**Consultation Response from KC,  
Highways Development Management**

**2025/93394 Rowley Mills, Penistone Road, Fenay Bridge, Huddersfield, HD8 0LE**

**Erection of 3 storey front extension and 2 storey rear extension of Rowley Mills with associated car park amendments, ancillary structures and landscaping; first floor roof extensions, car park amendments and landscaping at International House with new access infrastructure and pedestrian crossing facility**

**Date Responded:** 16<sup>th</sup> June 2026

STATUS: - REVISION: G

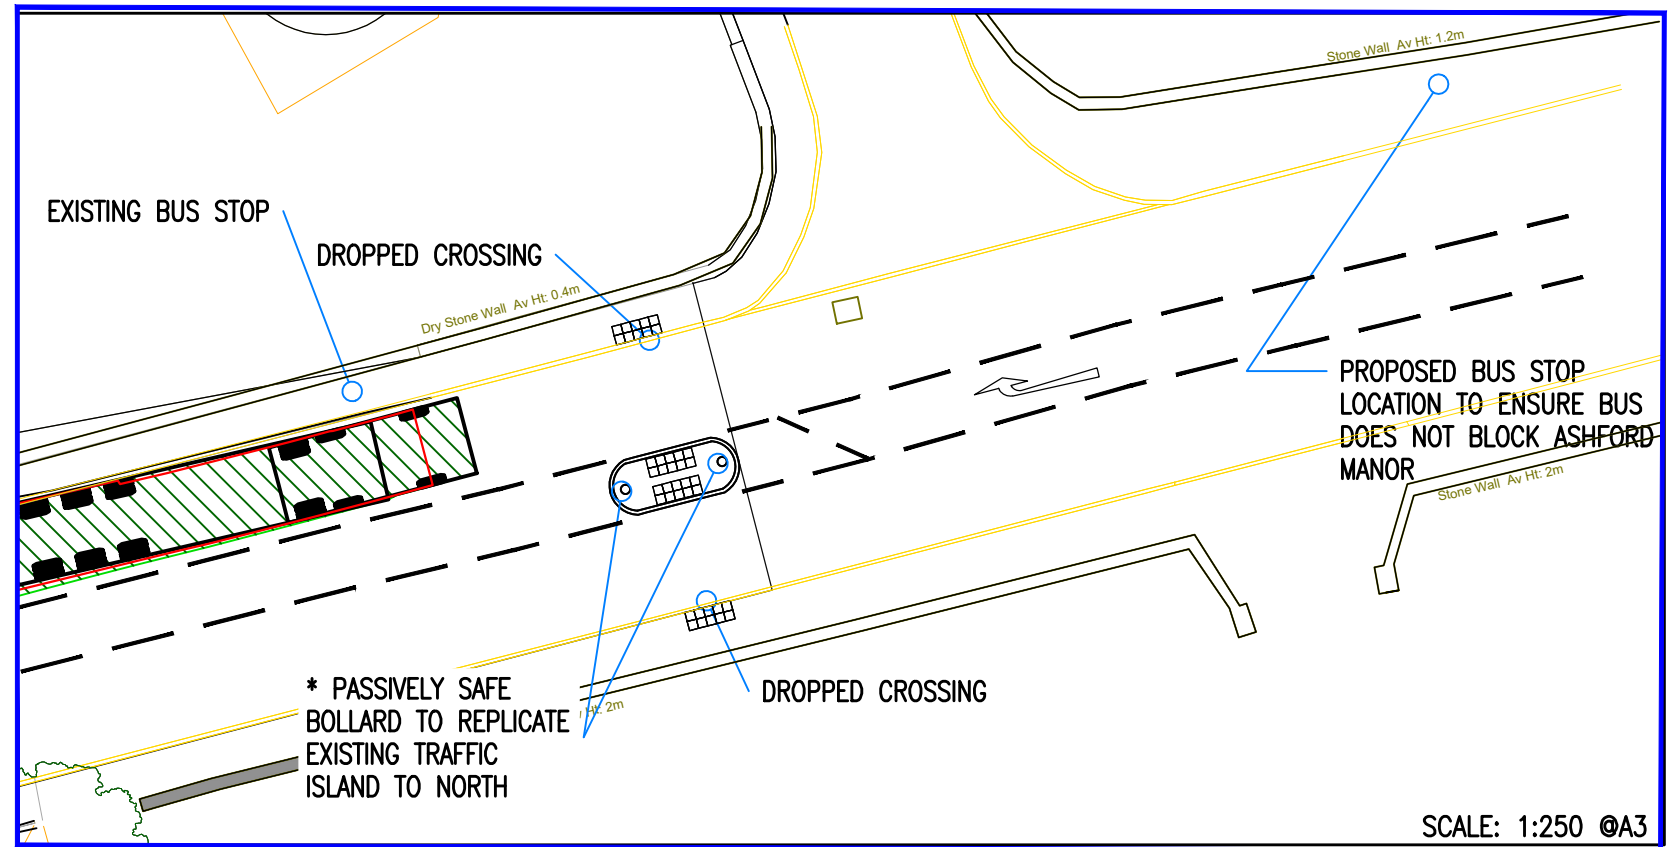
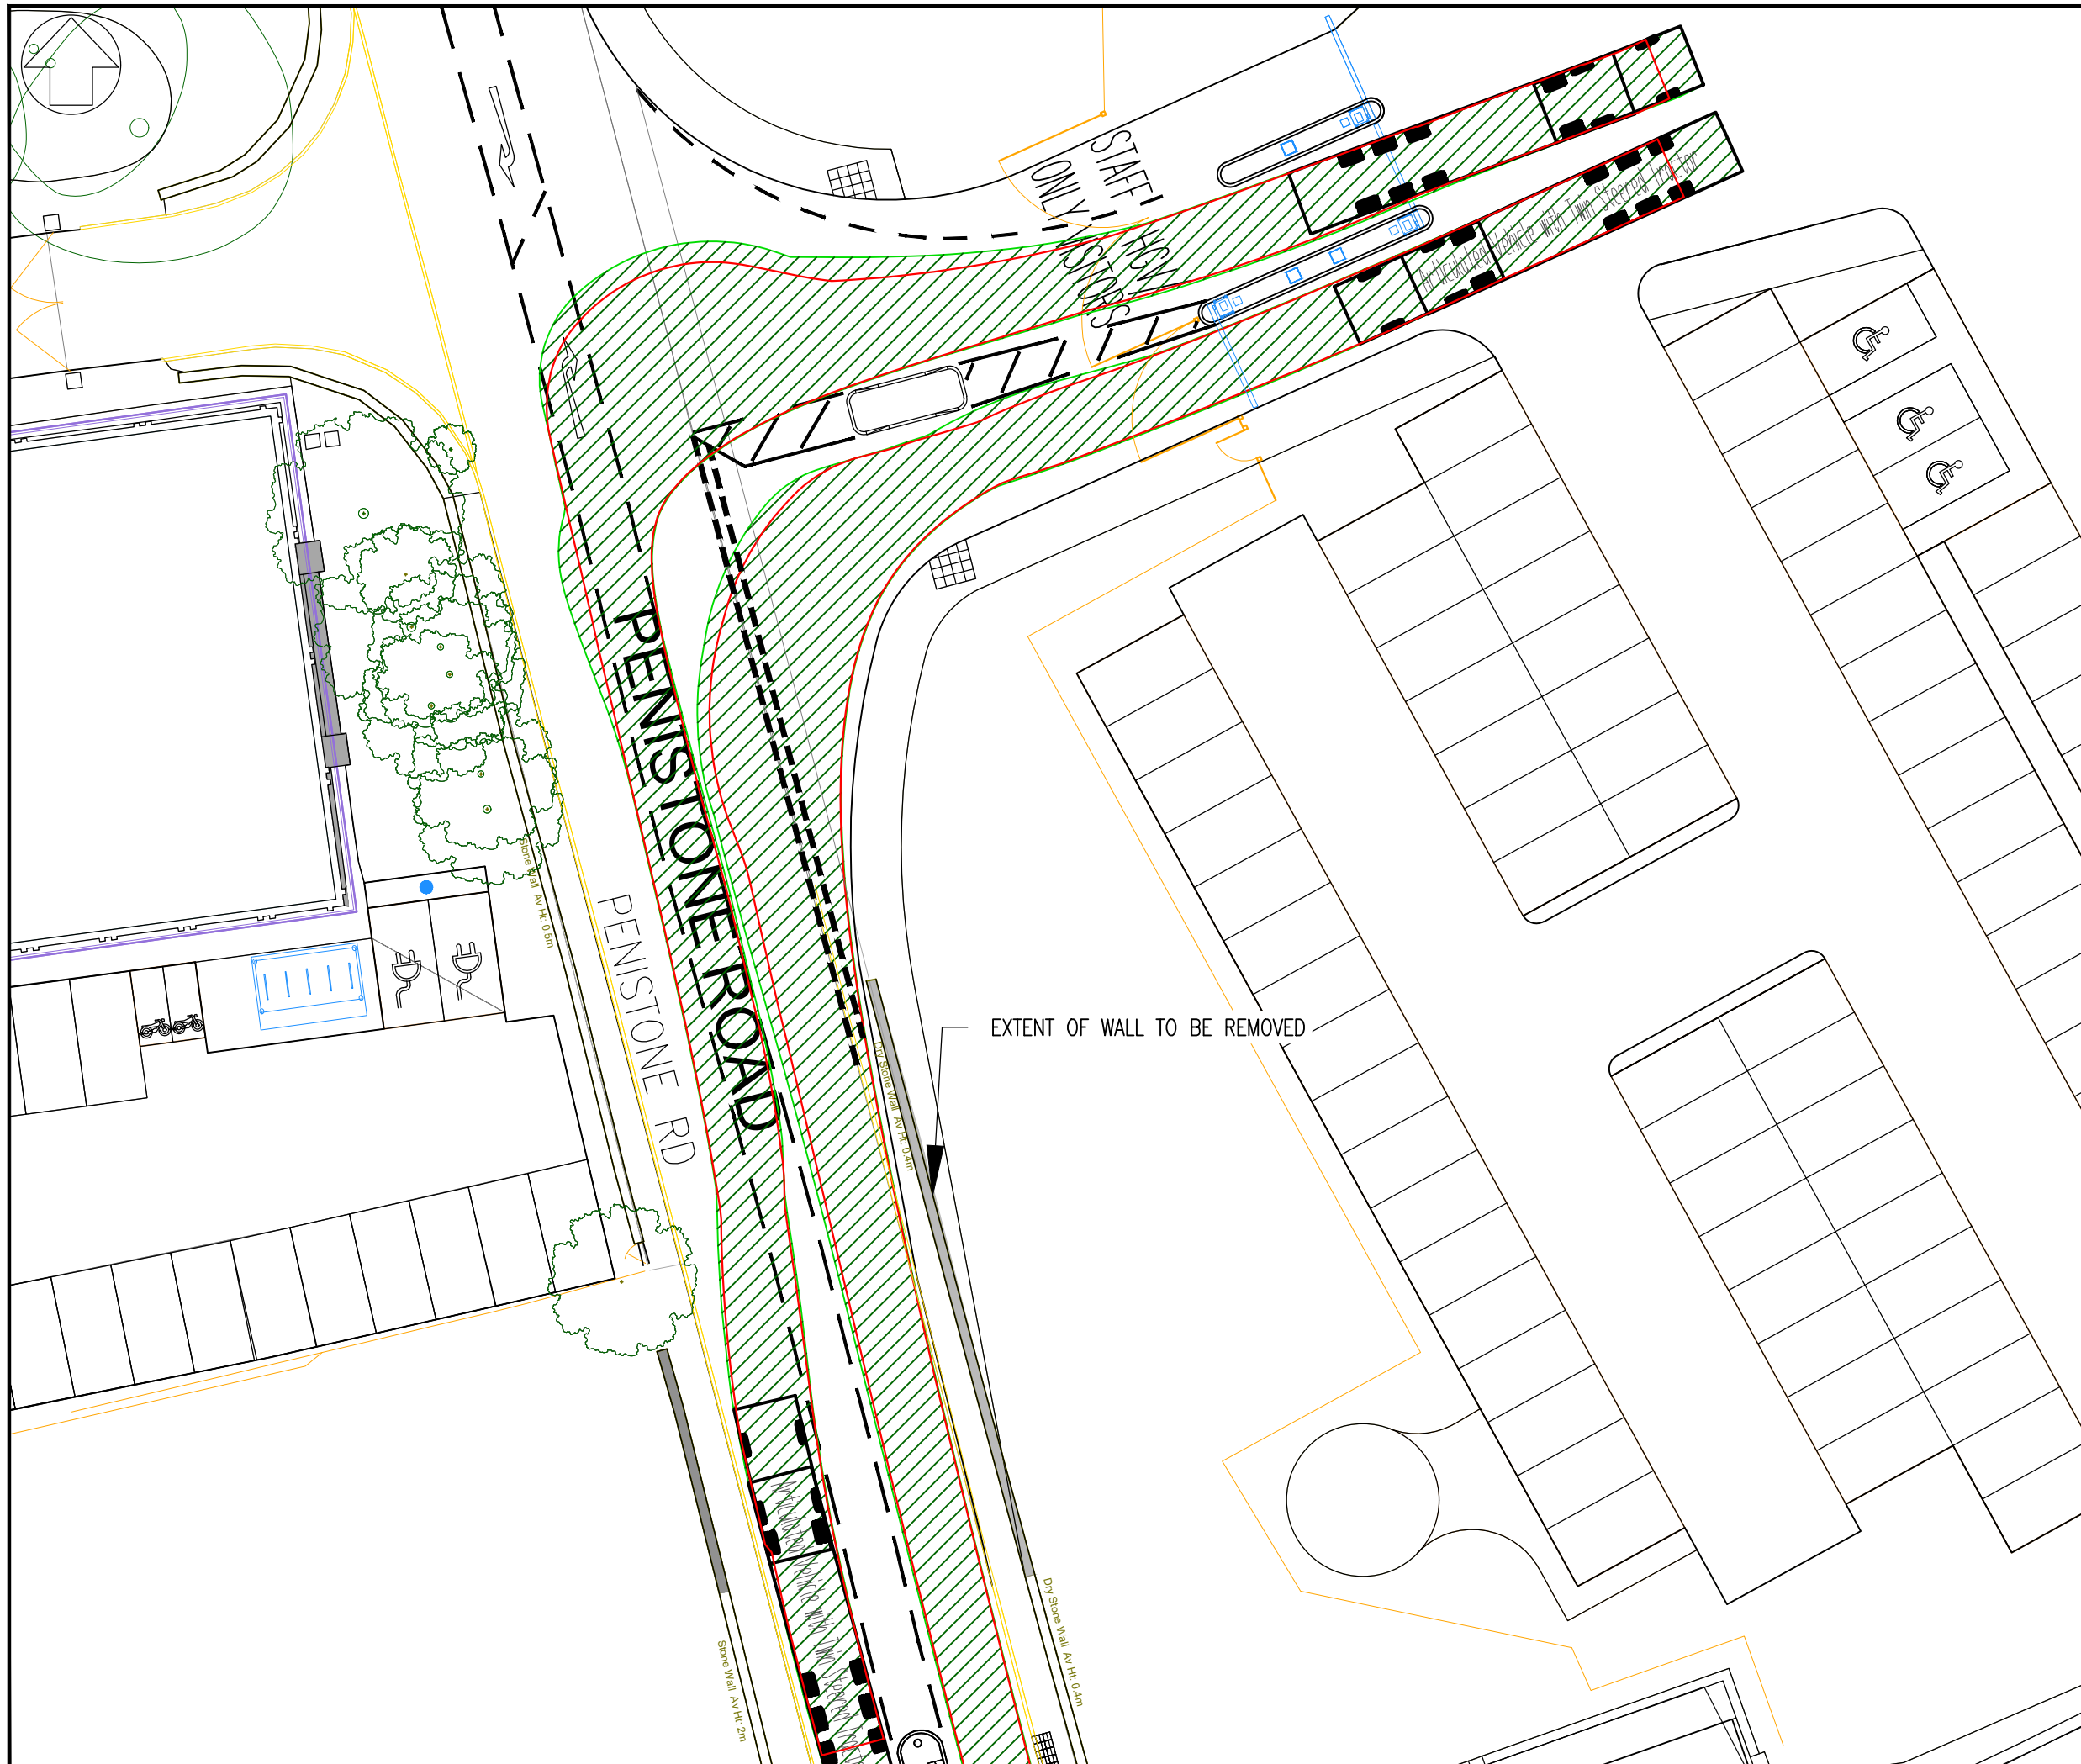
- Drawing No. 2310005 Rev. G – Proposed Pedestrian Crossing Island, should be amended to incorporate the dimensions (blue) and markings (red) shown on the extract below, which was provided following pre-application discussions.
- The island should also be dimensioned. The island should be wide enough to safely shelter pedestrians, but not so wide that lane widths are overly physically restricted, and/or there is inadequate clearance between the edges of the island and the lane marking. Given the overall cross-sectional dimension of 8.6m it is considered an island width of 1.8m should be adequate.

REV	DATE	BY	DESCRIPTION	APP
P03	19/11/2025	HT	ISLAND AMENDED	EG
P02	29/10/2025	HT	GENERAL AMENDMENTS	CY
P01	17/10/2025	LC	FIRST ISSUE	CY

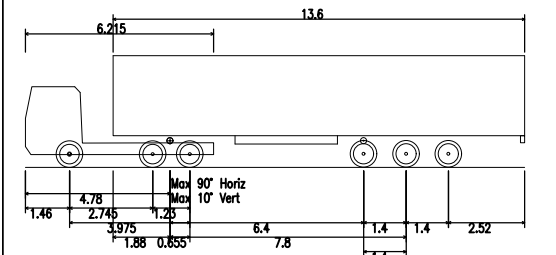
- Drawing No.2310010 Rev. P03 – Vehicle Swept Paths (extract below), the curved alignment of the lining demarcating the staff only and HGV lanes appears misleading guiding vehicles towards the HGV lane. Suggest the curved length of line markings are removed retaining a shorter straight section of demarcation with the introduction arrows directing vehicles to the appropriate lane.
